WELWYN HATFIELD COUNCIL – DEVELOPMENT CONTROL
DELEGATED REPORT

APPLICATION No:	N6/2008/2104/FP
------------------------	------------------------

DESCRIPTION OF PROPOSAL: It is proposed to erect a three storey extension on the south – eastern side of the property. The proposed extension would provide an additional 30 bedrooms, would feature materials and fenestration to match the existing building and would measure 25 metres wide, 14.6 metres deep and 12.7 metres tall.

Scale	Status	Date	Drawn	Checked
1:500 @ A3	PLANNING		PRM	
Drawing No.	Revision			
2587/P11

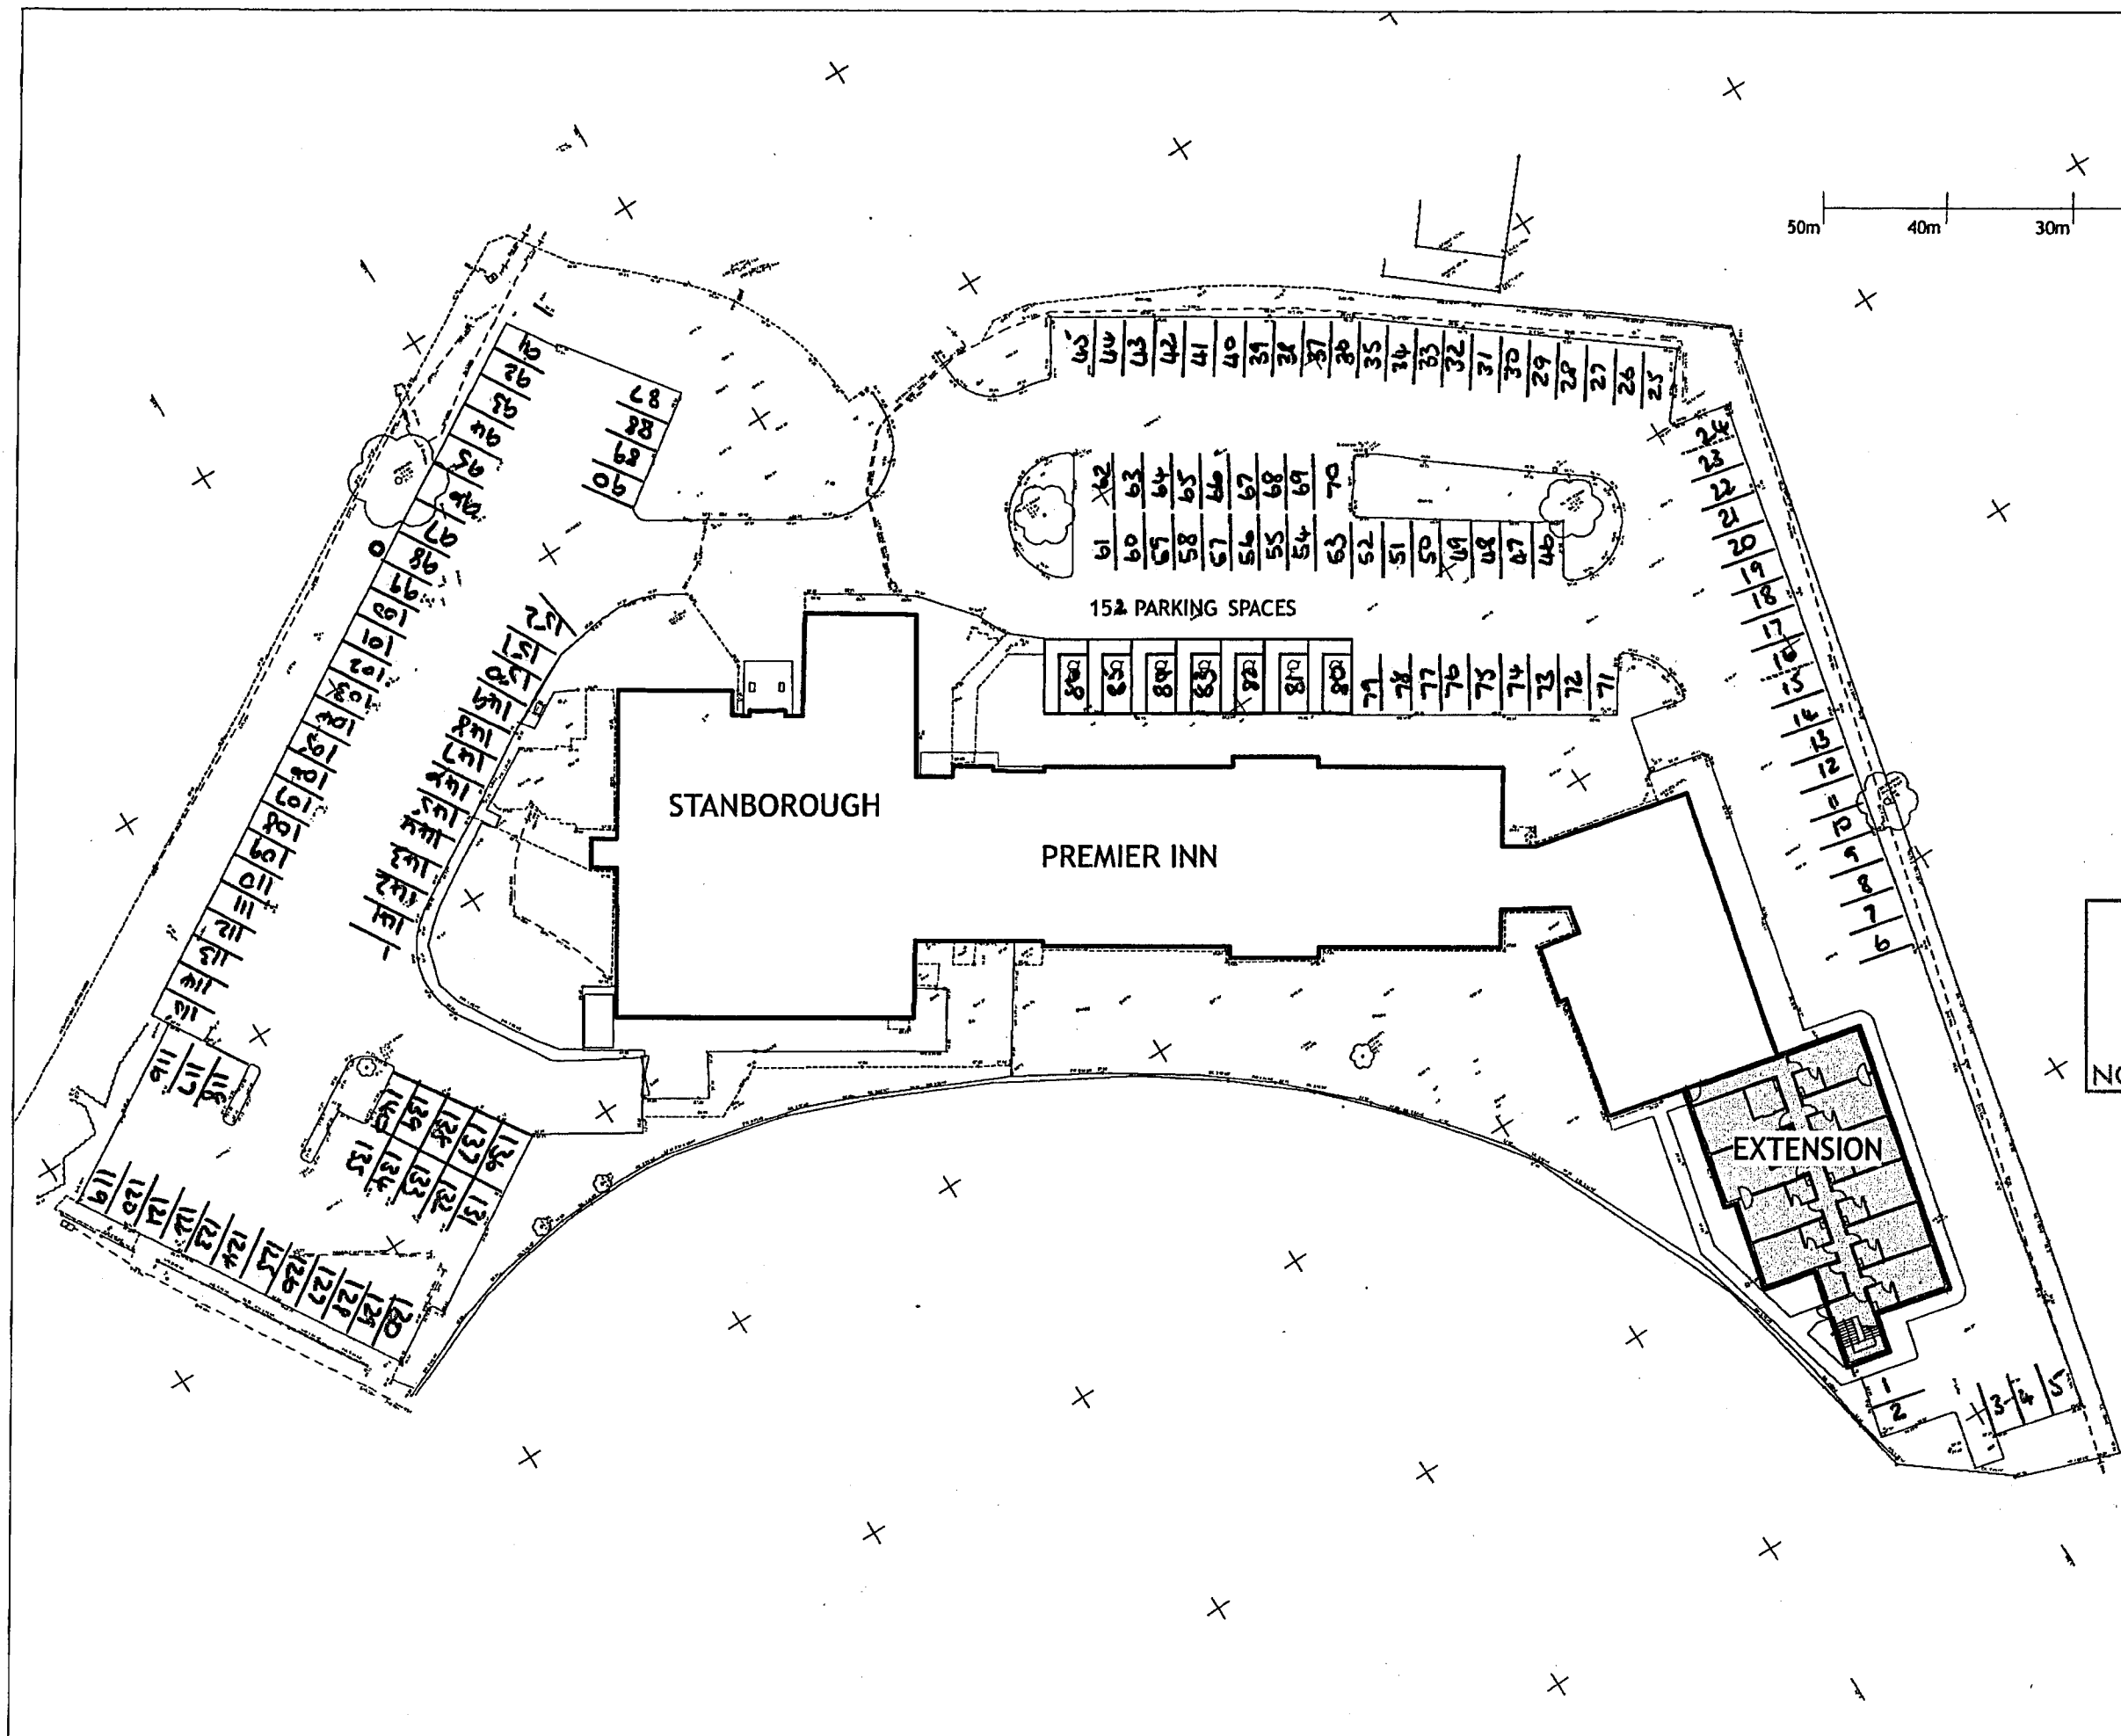
Unfortunately the applicant has failed to submit a detailed account of the number of staff that will be present on site at any one time. They have also not provided information as to the amount of space used for conference facilities. Indeed, whilst the application form has stated that there would be the provision of 164 parking upon further discussions a revised drawing was submitted [2587/P11] which annotates that there would only be a maximum parking allocation of 152 parking spaces.

If there was an allocation of 152 spaces as shown in the submitted drawing [2587/P11] then the applicant would only provide 72.4% of the total maximum standard of car parking spaces. The applicants has submitted a design and access statement and carried out two parking surveys which they have used to demonstrate the current usage of the car park. It has been stated that the results from the survey would justify the provision of 0.8 spaces per bedroom as apposed to 1 space per bedroom. This which would justify a reduction in the number of parking spaces at the facility from 120 spaces to 96 spaces. Further to this it is noted that the site is located in zone 4 in accordance with the Welwyn Hatfield District Plan 2005 and accordingly a reduction from the maximum standards would be considered to be appropriate. Following a consultation with Hertfordshire County Council Highways it was stated that the proposed "level of parking would not impact on the highway network". Given the evidence provided through the applicant's parking surveys and the position of the application site in relation to the town centre (zone 4) it is considered that a reduction from the maximum parking standards would be appropriate and in this instance the provision of 152 parking spaces would be appropriate for the potential use of the site.
